Our Case Number: ABP-317560-23

Re: Proposed windfarm development including 13 no. wind turbines in Bunnyconnellan, Co. Mayo and hydrogen plant in Castleconnor, Co. Sligo.
Carrowleagh, Bunnyconnellan, Co. Mayo and Curraun, Castleconnor, Co. Sligo.

Reply to Jennings O Donovan in relation to case ABP 317560-23

We would like to highlight some of the short fallings within Jennings O'Donovan Consulting Engineers response to third party submissions and observations planning application Ref ABP 317 560-23.

Figure 15.13: Junction Turning Movements at N59 / L-6612-1 – AM Period

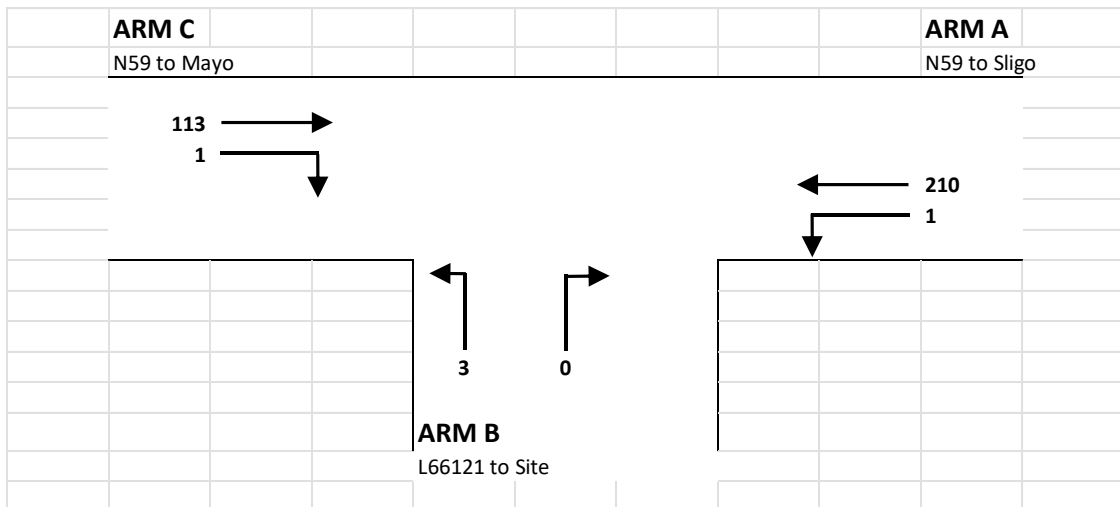
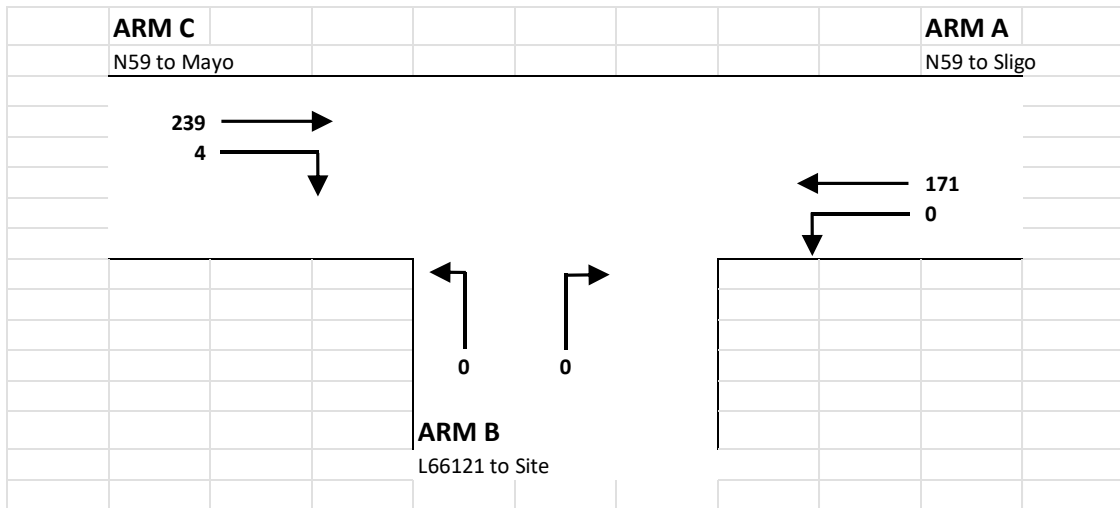
"
Incorrect Labeling of Junctions'

L6612 is an entirely different junction 600m away. It is deeply concerning that this error may lead to huge confusion. Some experts may have inadvertently examined the wrong junction, throughout the preparation of the planning application. Evidence of this can be found on a TII document, a Sligo Co Co document (which was later corrected by council at a meeting 4 Sept. 2023)

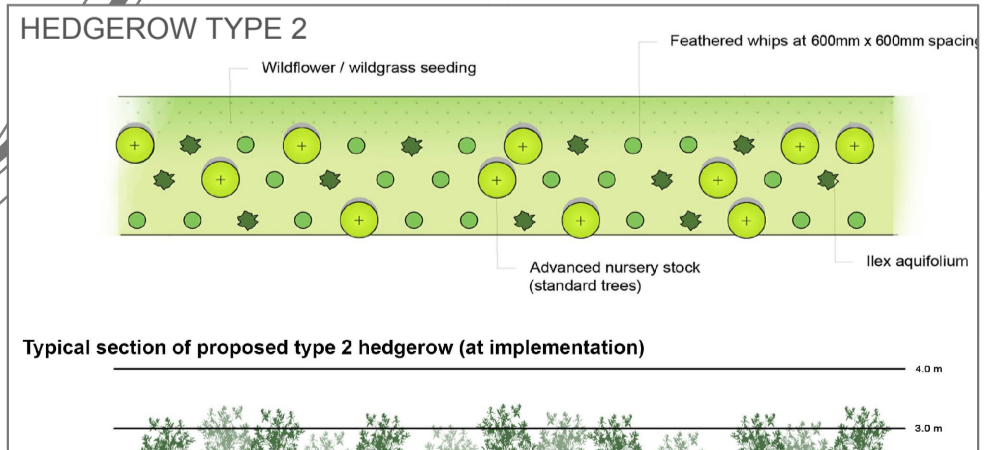
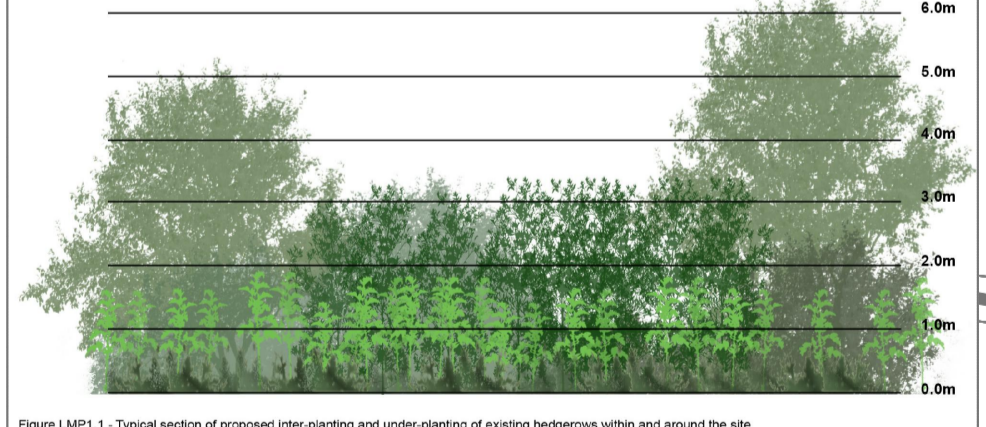
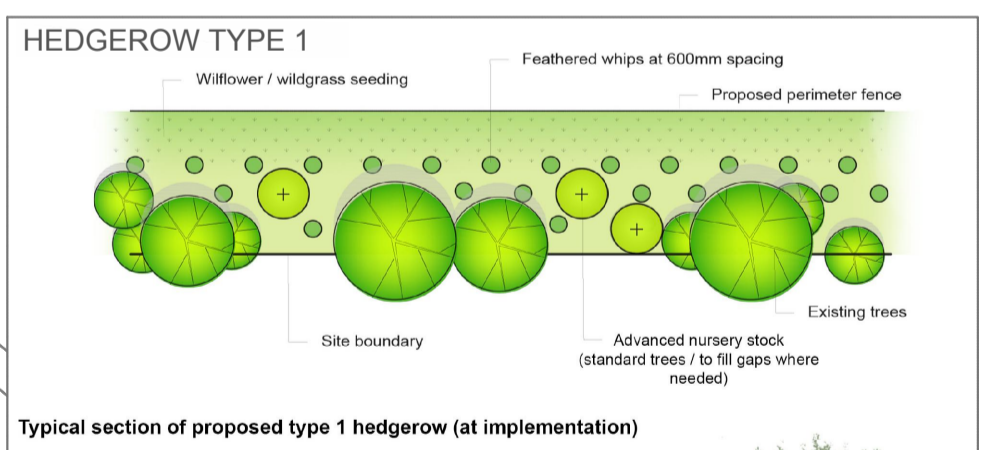
Furthermore, the proposed Hydrogen Plant photo montage gains some screening, but it is not clear what form this will take, and if screening is compromised of trees, will they be

mature trees as opposed to saplings and where they will be planted - at the top or bottom of bank.
